**Development Facilitation Team (DFT) – Review Comments**

**Project No: PR-2024-010933    Date: 6/11/2025    Agenda Item: # 10    Zone Atlas Page: J-13**

**Request: Waiver to DPM Section 7.2(D) and Specifically Table 7.2.29.**

**Location: 1736 Central Ave SW between Central Ave. and Chacoma Pl SW 2.394 acres**

Plat of Garcia's Kitchen Redevelopment Being a Replat of Lots 1 and 2 of Garcia Properties Development and M.R.G.C.D. Tracts 131 and 132 of Property Map No. 38

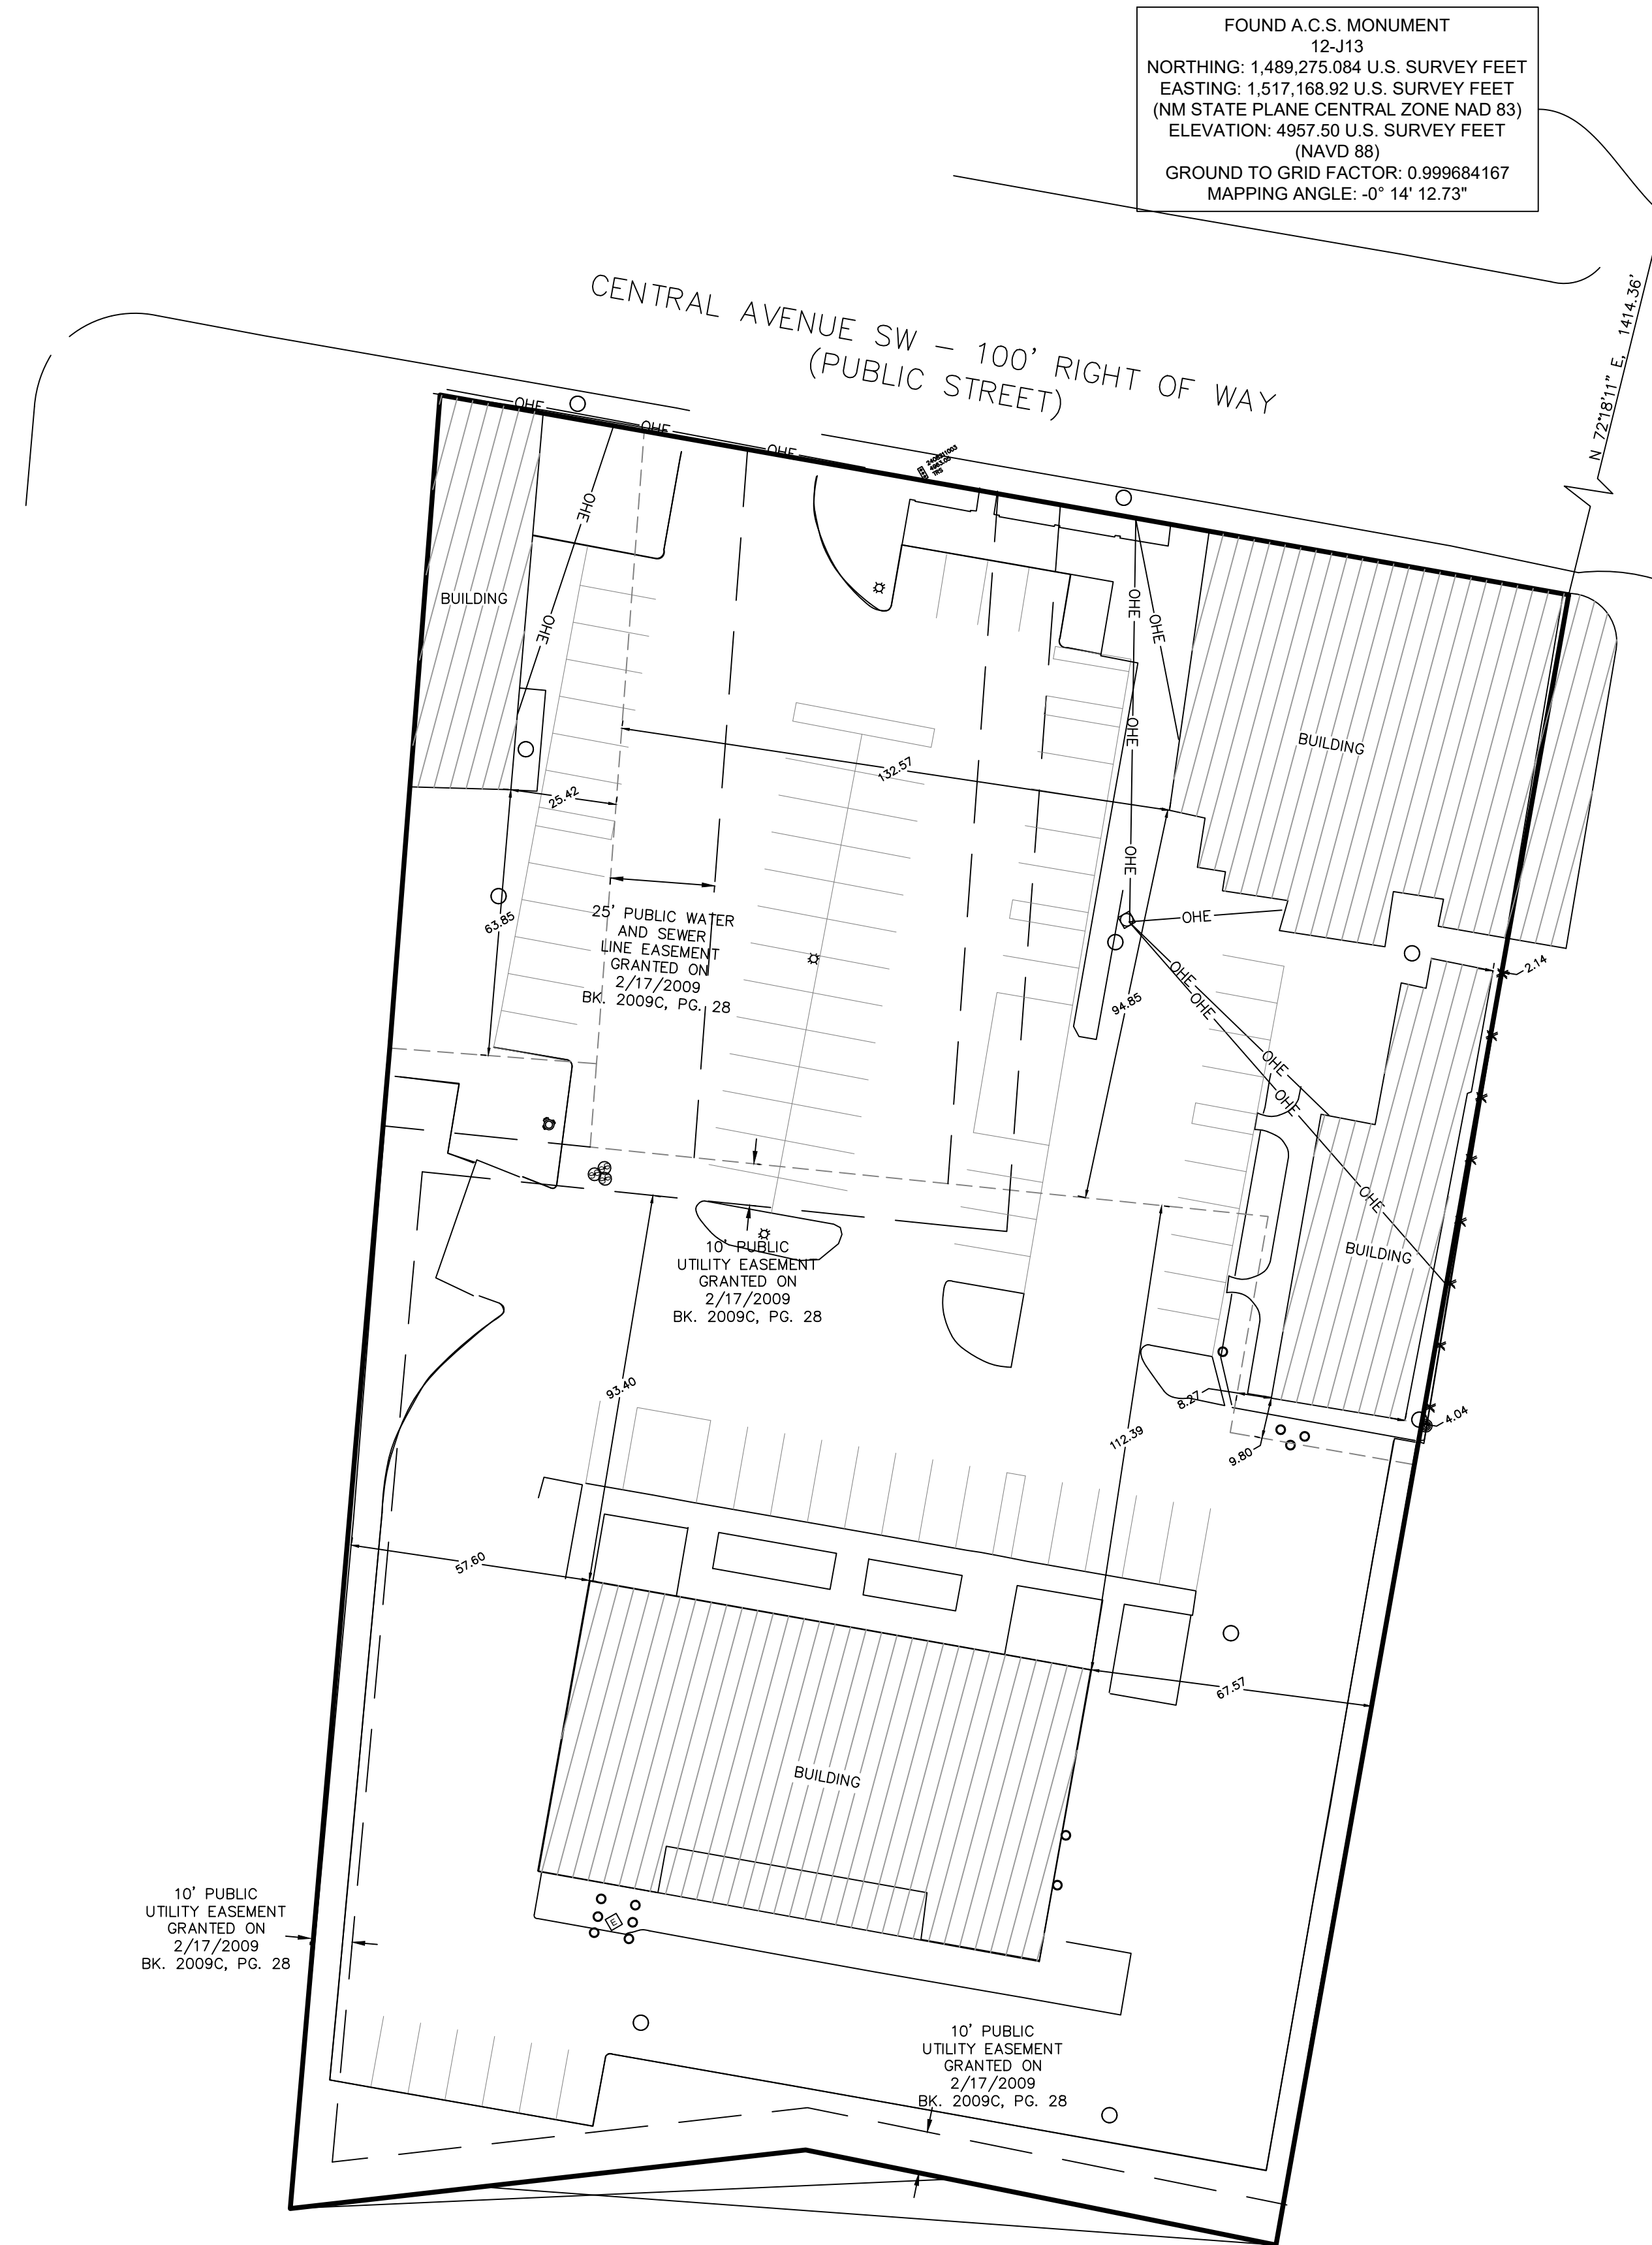
- A note must be added to the Plat regarding the request (approval) of this waiver from the Development Hearing Officer (DHO) to allow narrower sidewalk along Central Ave. NW.
- Per Table 6-4-3 of the IDO, a Sidewalk Waiver expires within 1-year if not platted and expires with associated Site Plan if approved by the DHO.
